Appendix 7

Road Safety Audit and Designer's Response

Road Safety Audit – Lidsey Road, Woodgate

Location: A29 Lidsey Road, Woodgate, West Sussex

B	Updated site access arrangements	BL	18.02.22
A	Updated site access arrangements	BL	10.02.22
ISSUE	REASON FOR REVISION	BY	DATE

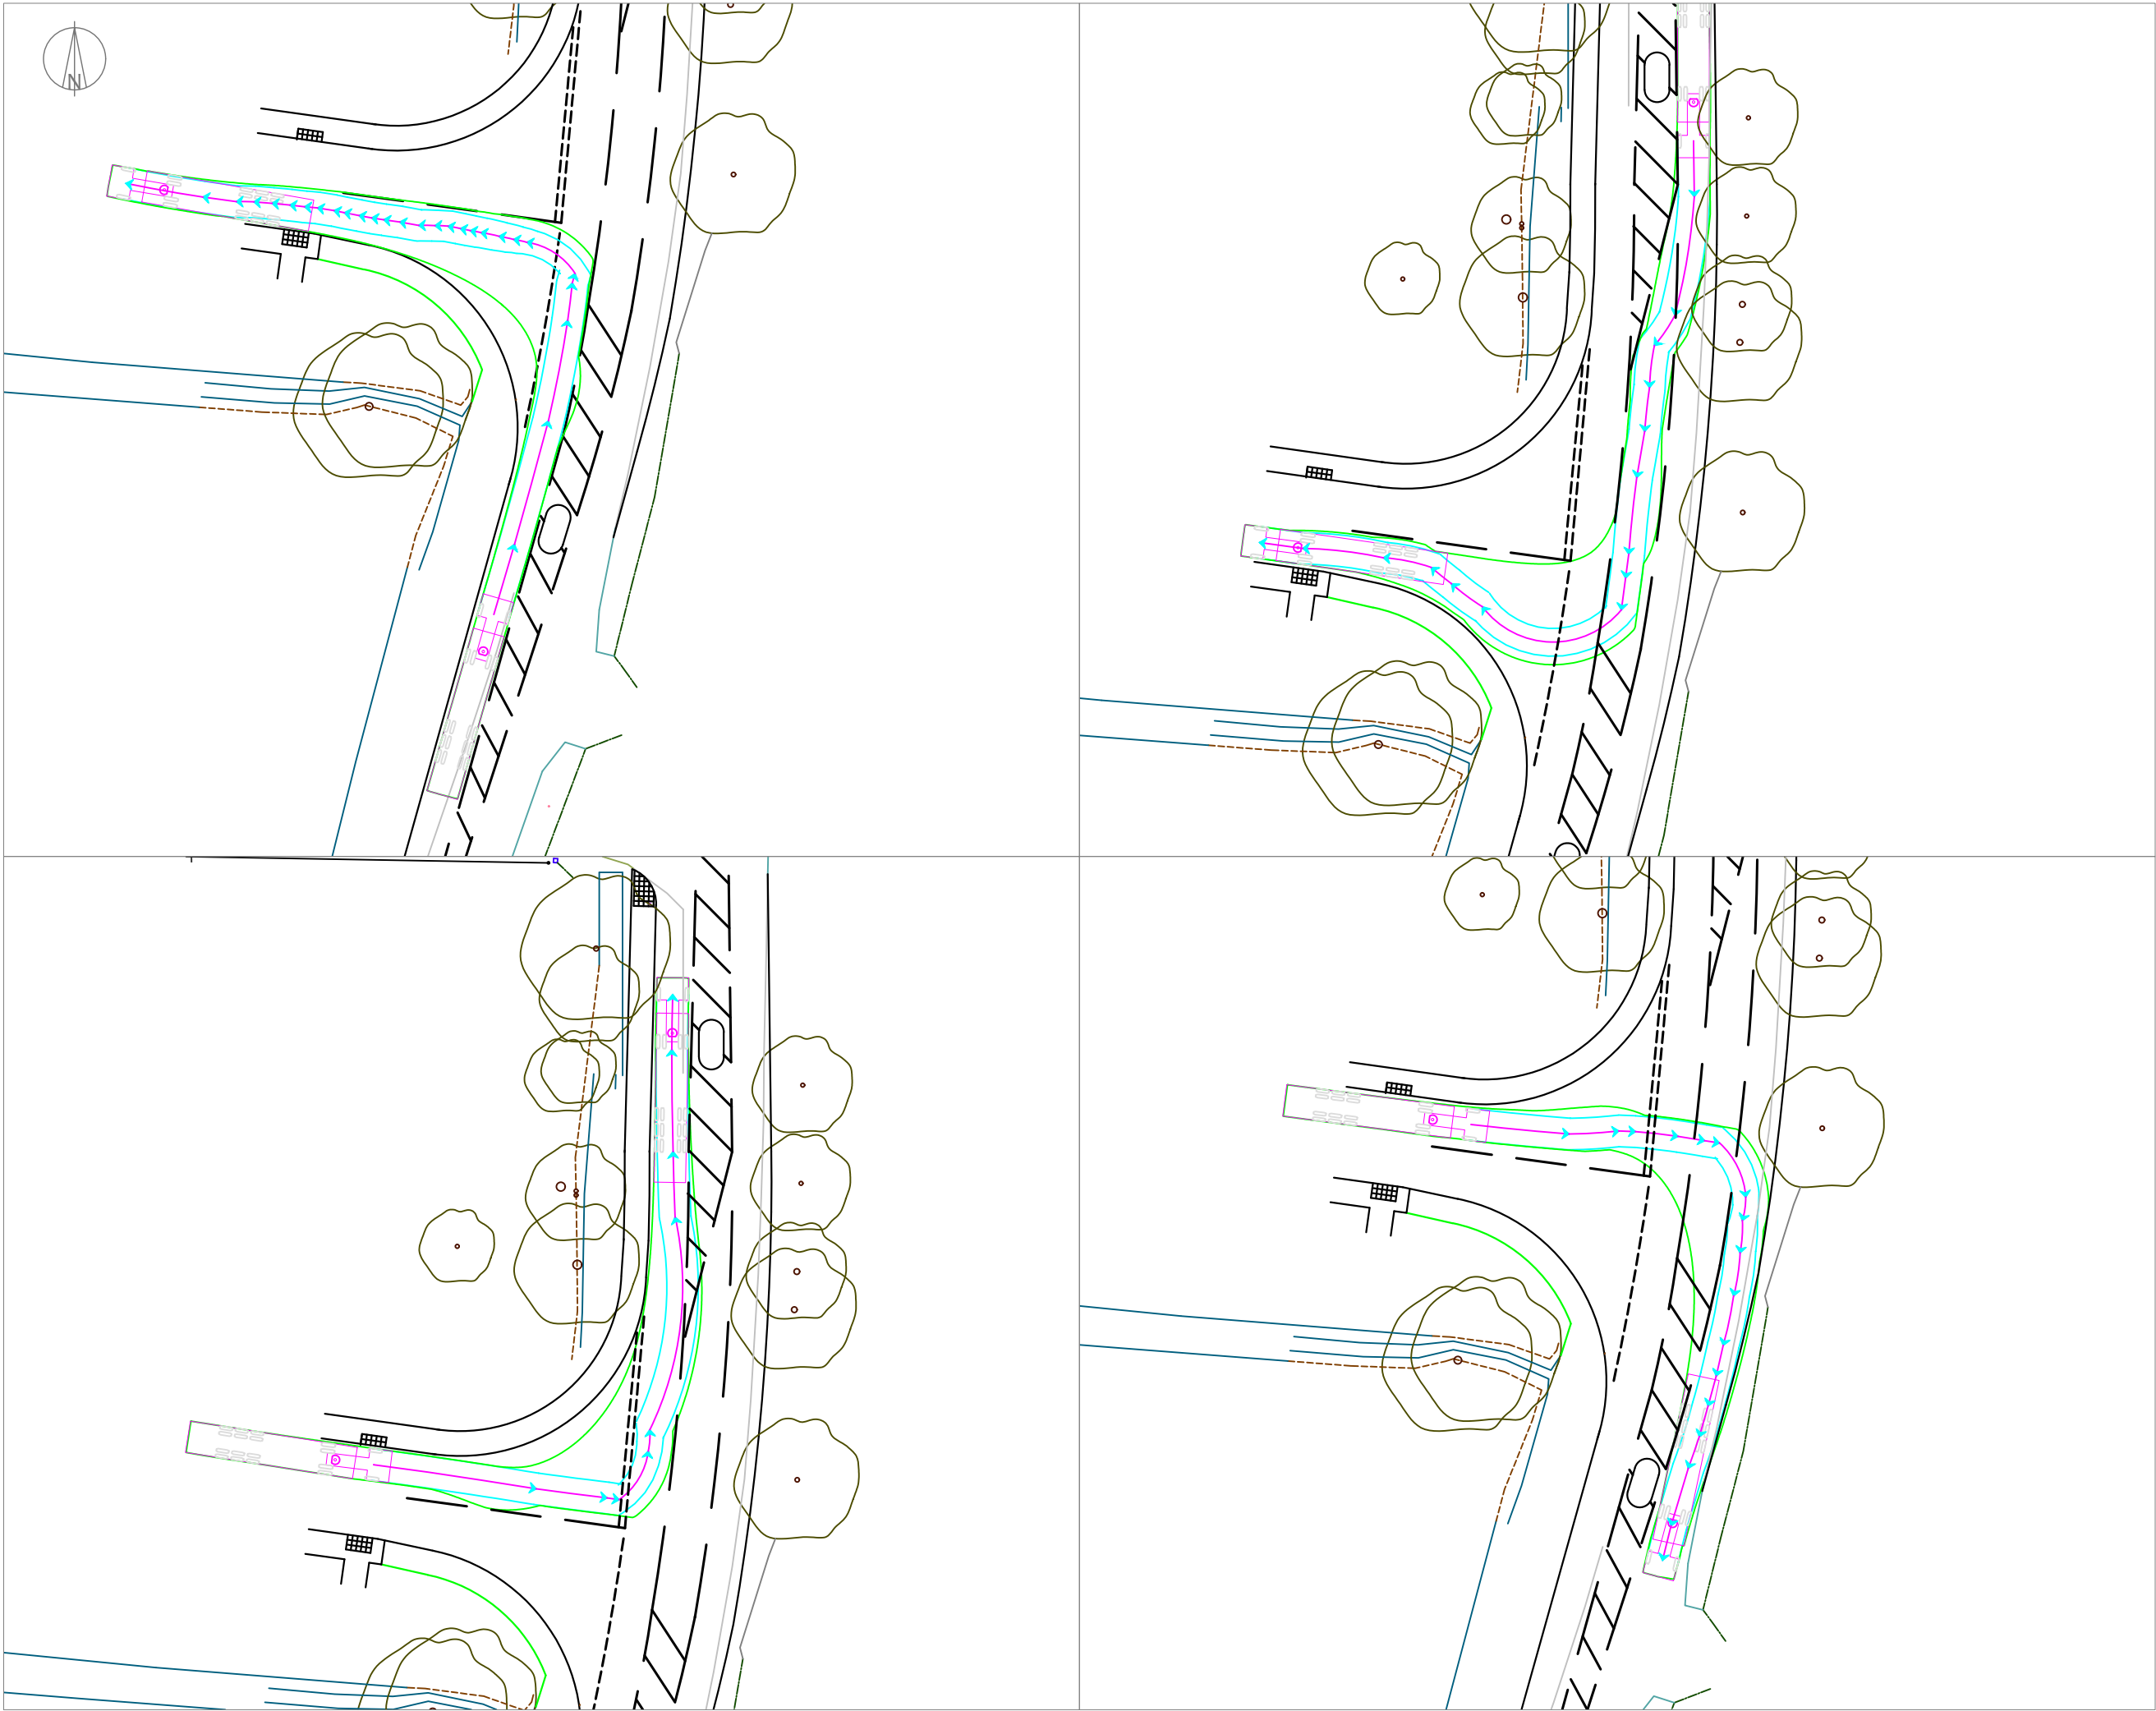
It is unclear from the drawing whether existing trees and vegetation will be removed to satisfy the visibility splay. This is problematic especially for the northbound direction around a bend prior to the access road. It is noted that the scheme will straighten the bend slightly so will improve visibility however this is likely to also increase speeds.

Recommendation – Remove vegetation to the north and especially south of the proposed access road. Investigate extending the existing 30mph further south to include the new junction.

The northbound approach view to the access road is on a bend and although proposed to be slightly straightened with carriageway widening, drivers may not be aware of the new junction and the potential number of vehicles exiting and entering. This could lead to late braking behind a turning vehicle and result in rear end shunts or a side swipe type collision with a vehicle exiting the access road.

Recommendation – Install junction warning sign prior to access road. Investigate extending the existing 30mph further south to include the new junction.

At the new proposed traffic islands, a carriageway width of 3.2m and 3.5m has been proposed. Gaps of between 3.2m and 3.9m should be avoided as they increase conflict between motor vehicles and cyclists because they are not wide enough to allow vehicles to overtake cyclists, or narrow enough to discourage overtaking.

Recommendation – Reallocate road space or widen traffic island to ensure widths between 3.2m or 3.5m are avoided.

There is currently a level difference between the edge of the carriageway and the back of the existing verge to the culvert. A steep gradient may result in pedestrians, particularly the elderly and those with mobility impairment, slipping and falling, potentially into the culvert.

Recommendation – Construct the new footway such that its gradient is appropriate for pedestrian use. Ensure there is no level difference between the back of the footway and the adjacent verge and that pedestrians are protected from falling into the culvert using restraint.

Para	Location/Problem	Recommendation	Designer's Response
2.1	Proposed access road at A29 It is unclear from the drawing whether existing trees and vegetation will be removed to satisfy the visibility splay. This is problematic especially for the northbound direction around a bend prior to the access road. It is noted that the scheme will straighten the bend slightly so will improve visibility however this is likely to also increase speeds.	Remove vegetation to the north and especially south of the proposed access road. Investigate extending the existing 30mph further south to include the new junction.	Partially accepted – Vegetation within the visibility splays has been removed and will be maintained to ensure that the visibility splays will not be impacted. A note has been added to the updated access drawing (2087/29/C). There are no proposals to extend the 30mph speed restriction.

2.2	Northbound approach to new access road on A29 The northbound approach view to the access road is on a bend and although proposed to be slightly straightened with carriageway widening, drivers may not be aware of the new junction and the potential number of vehicles exiting and entering. This could lead to late braking behind a turning vehicle and result in rear end shunts or a side swipe type collision with a vehicle exiting the access road.	Install junction warning sign prior to access road. Investigate extending the existing 30mph further south to include the new junction.	Not accepted – The access junction will be visible for around 300 metres for northbound vehicles which is considered more than sufficient. Nevertheless a comment has been added to the access drawing stating <i>"Provision of permanent or temporary junction warning signage to be discussed with council engineers as part of the Section 278 process."</i> There are no proposals to extend the 30mph speed restriction.

2.3	Proposed traffic islands on A29 At the new proposed traffic islands, a carriageway width of 3.2m and 3.5m has been proposed. Gaps of between 3.2m and 3.9m should be avoided as they increase conflict between motor vehicles and cyclists because they are not wide enough to allow vehicles to overtake cyclists, or narrow enough to discourage overtaking.	Reallocate road space or widen traffic island to ensure widths between 3.2m or 3.5m are avoided.	Not accepted. The access has been designed in accordance with DMRB GG 123 and verified by swept path analysis given the location of the access on a bend in the A29. GG 123 states: Paragraph 6.8 "At ghost island junctions on roads other than WS2+1 roads, the through lane widths in each direction shall be a minimum of 3.0 metres and a maximum of 3.65 metres wide, exclusive of hard strips". Paragraph 6.10 The width of the right turning lanes for new junctions, excluding WS2+1, shall be a minimum of 3.0 metres. Paragraph 6.10.1 The width of the right turning lane at new and existing junctions should be 3.5 metres. Paragraph 6.10.2 On rural roads, with design speeds above 85 kph or where hard strips are present, the width of the right turning lane at new and existing junctions should not exceed 3.65 metres. Given the road to either side of the junction allows overtaking, has good forward visibility and the observed very infrequent use by cyclists it is concluded that the frequency of overtaking attempts on cyclists through the junction will so infrequent as to be inconsequential.

It is therefore concluded that the lane widths are appropriate and accord with national design standards. This will be considered further at the detailed design stage.

2.4	Proposed footway to north of proposed access on A29 There is currently a level difference between the edge of the carriageway and the back of the existing verge to the culvert. A steep gradient may result in pedestrians, particularly the elderly and those with mobility impairment, slipping and falling, potentially into the culvert.	Construct the new footway such that its gradient is appropriate for pedestrian use. Ensure there is no level difference between the back of the footway and the adjacent verge and that pedestrians are protected from falling into the culvert using restraint.	Accepted – The level difference between the edge of the existing road (bottom of kerb) and the edge of the site is approximately 0.35 metres. The footway into the site will be designed at maximum gradient of 1:20. Should there be any risk of pedestrians slipping or falling into the culvert, then providing a restraint system will be investigated. The site access proposals have been updated to reflect the above.
